PLANNING AMENDMENT

H12/1058/99

RESIDENTIAL DEVELOPMENT (4NO PLOTS)

Description: Erection of one 3, two 4 bed
detached houses, and one 4 bed
detached bungalow all with
double garages

1:200 99001/2

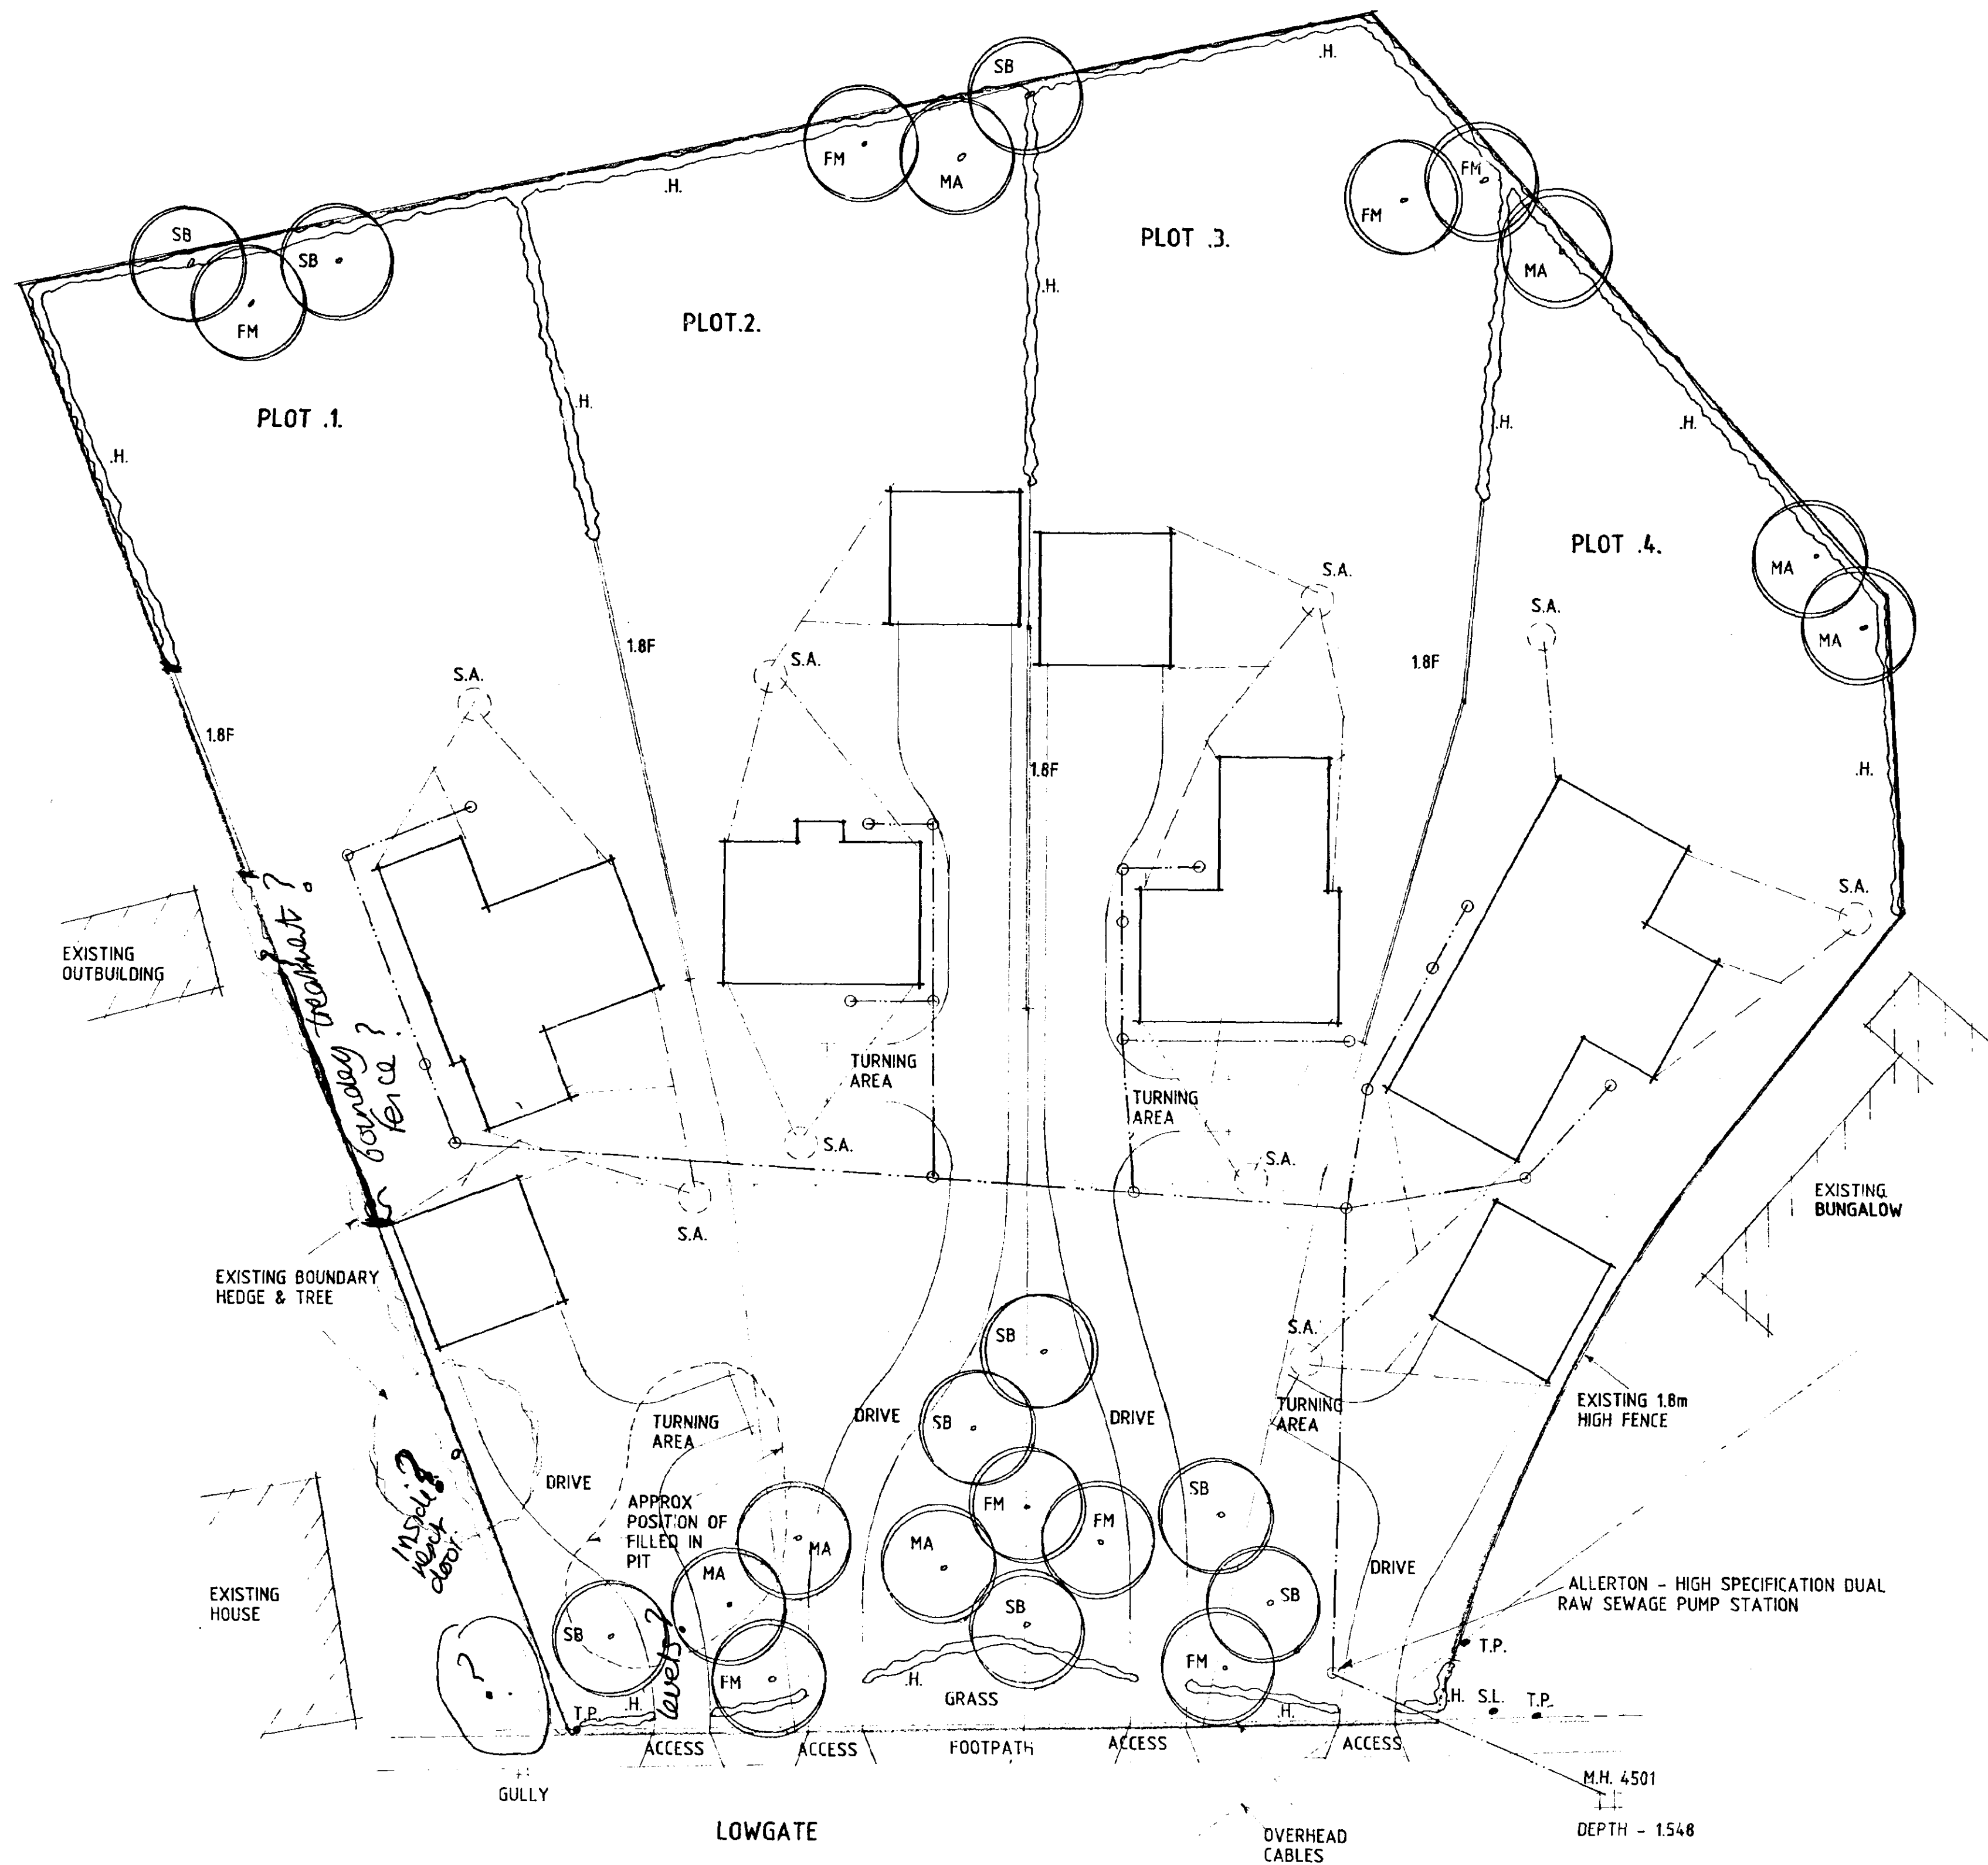
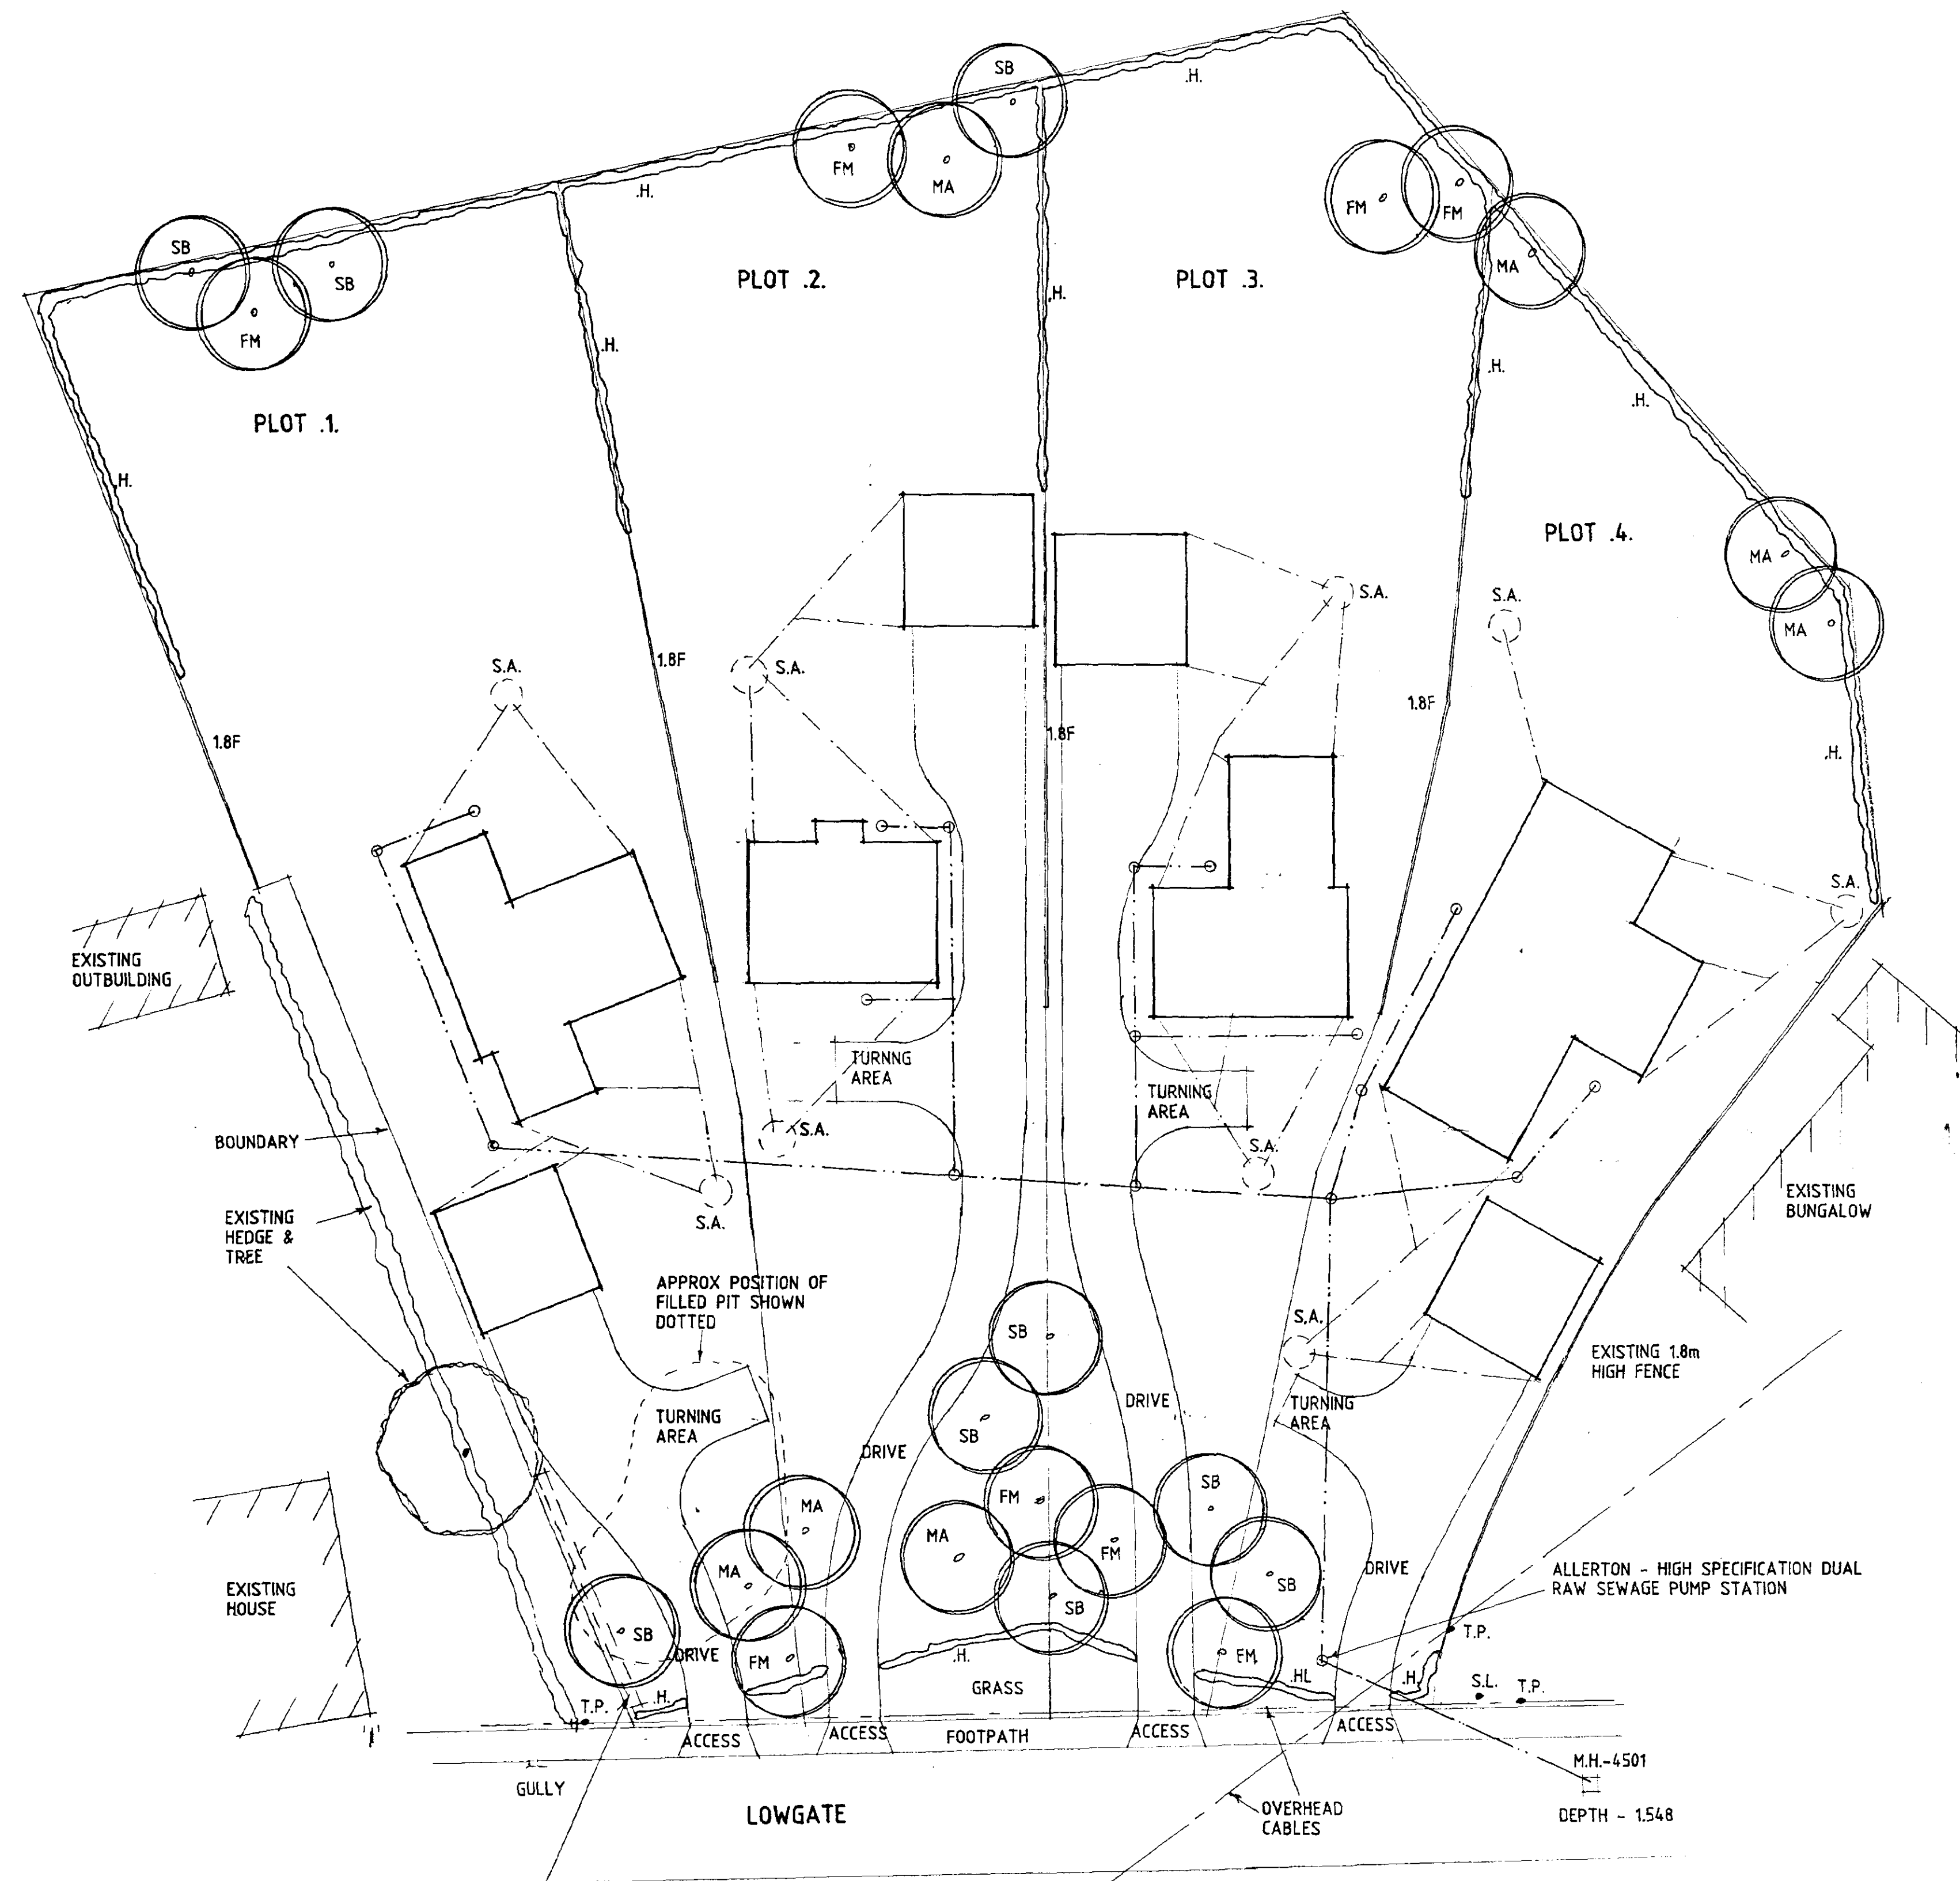
Amendment: Amended boundaries (Dwg no. 99001/2)

BOUNDARIES.

1:200 1:2500 99001/1

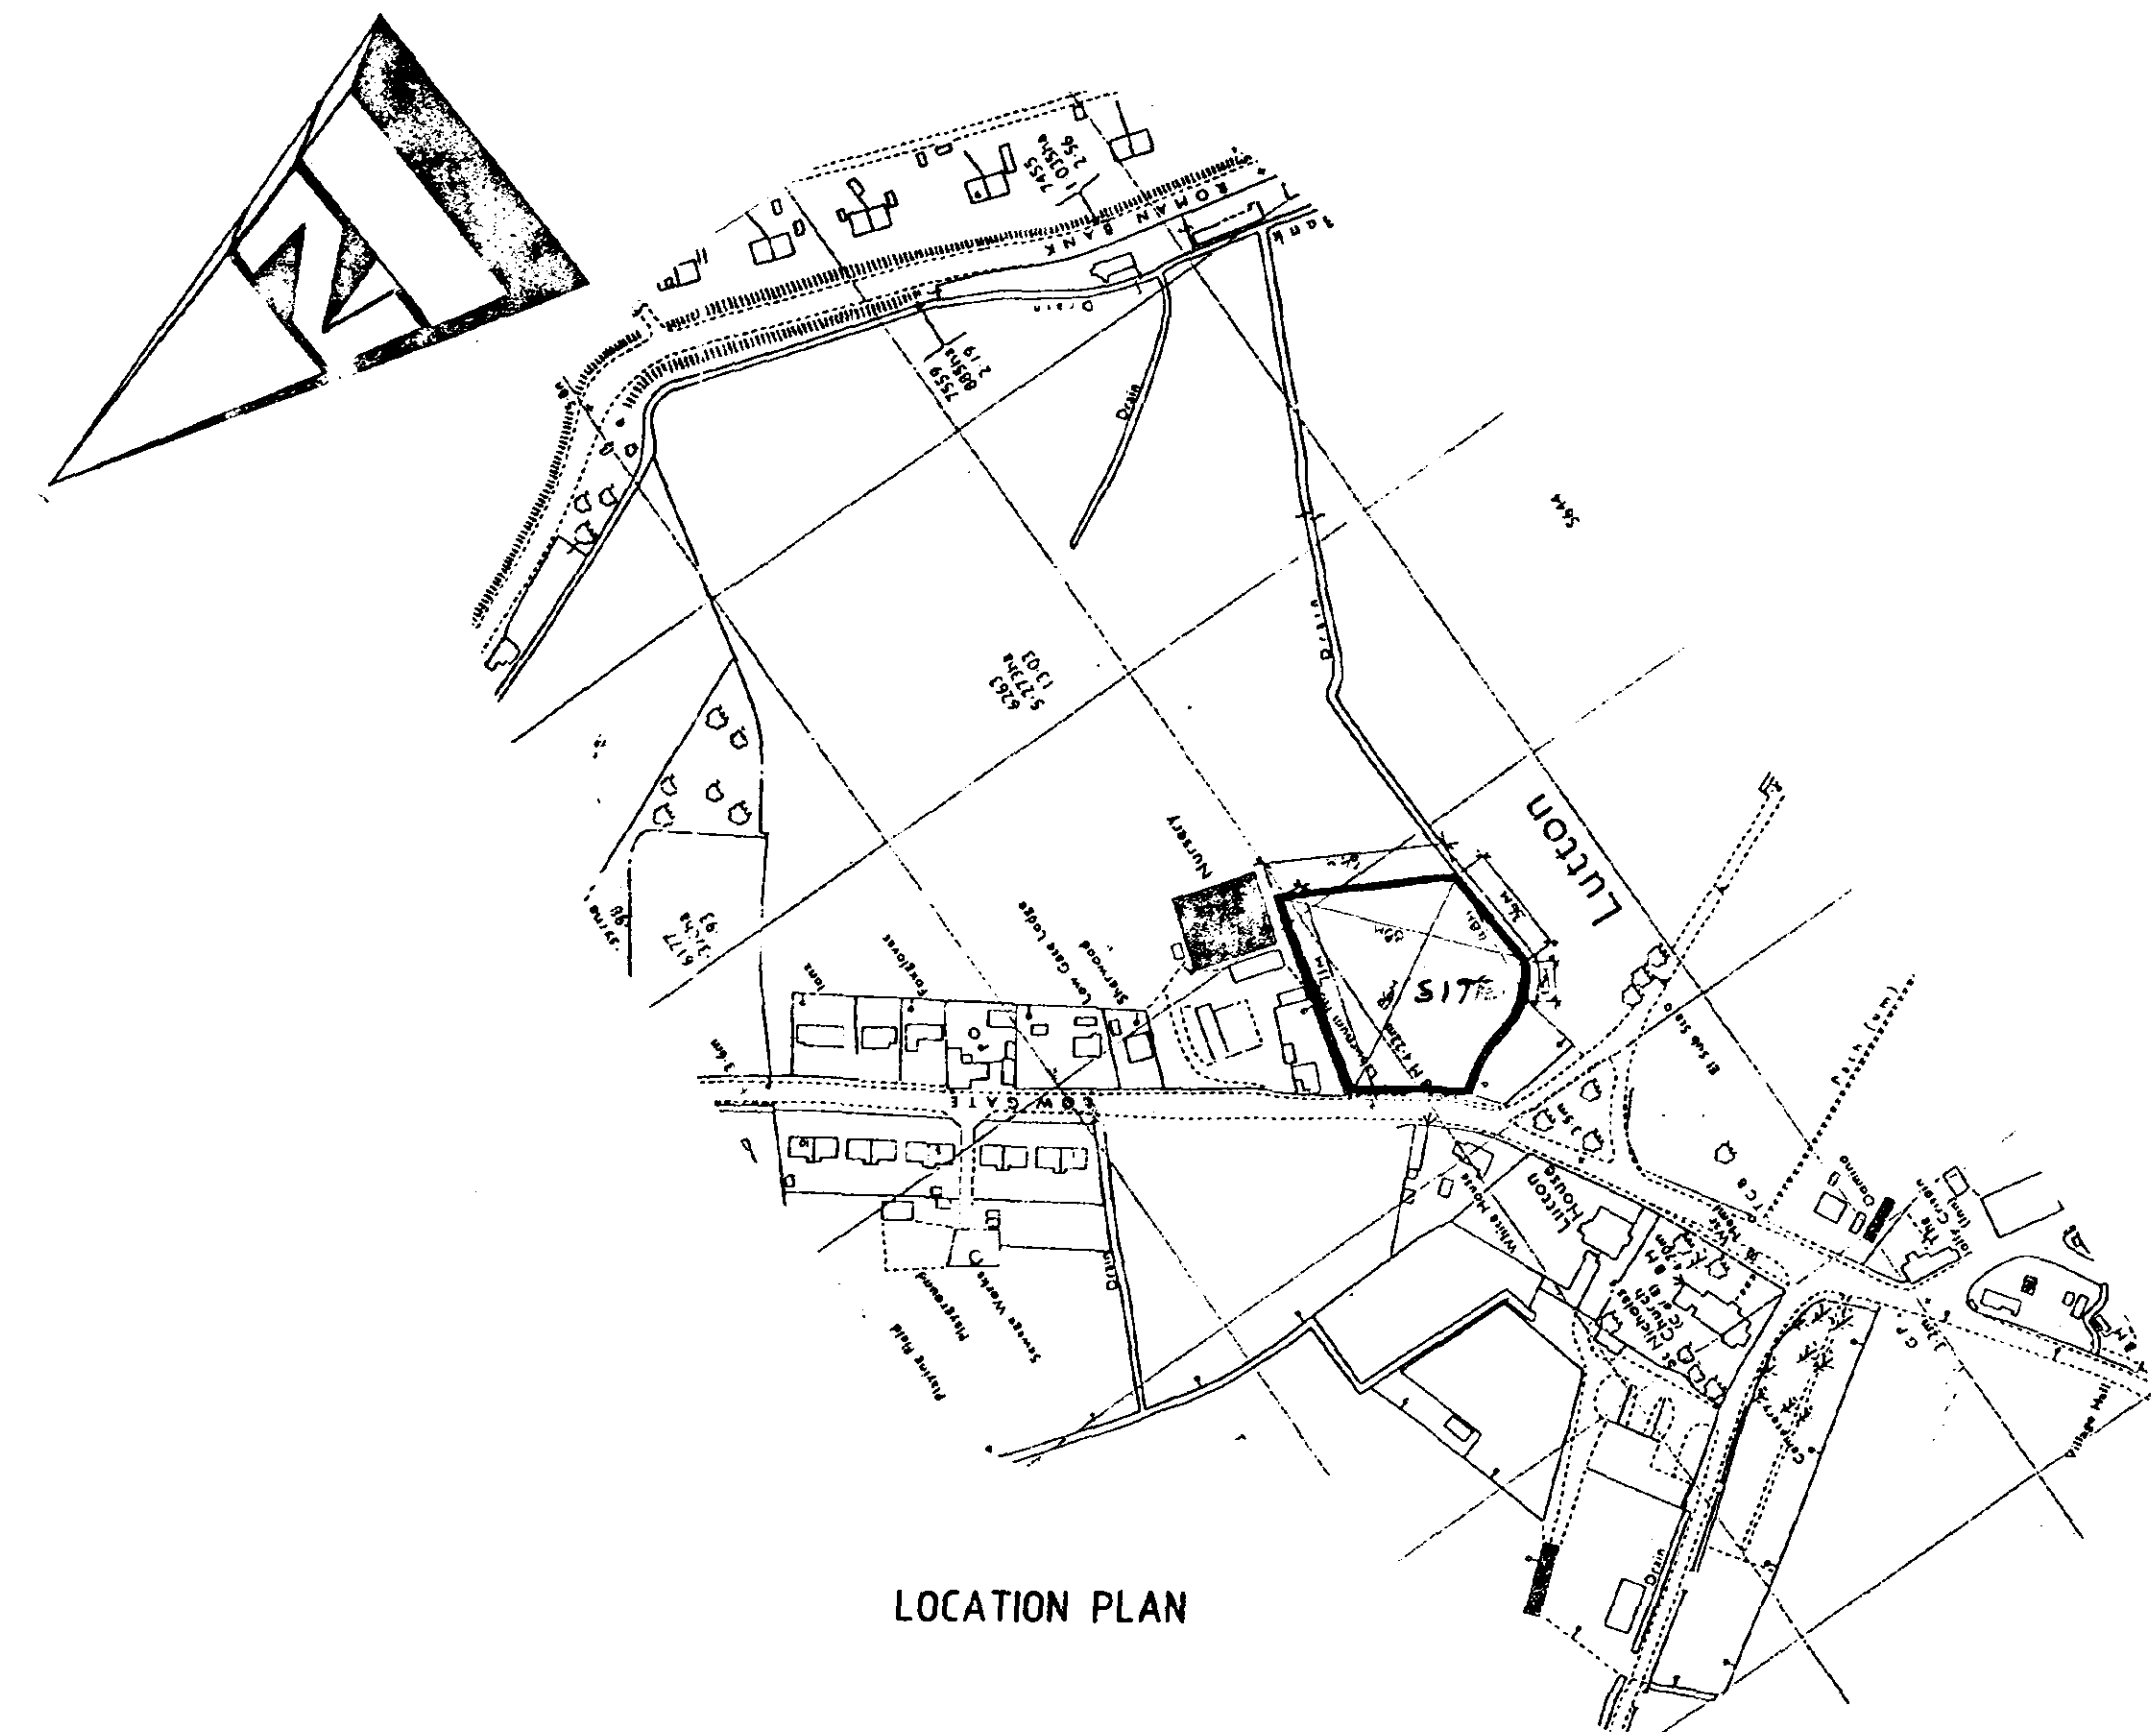
ADDITIONAL FENCE & FRENCH DRAIN

Amendment: Additional fence and french drain
Dwg. No. 99001/1
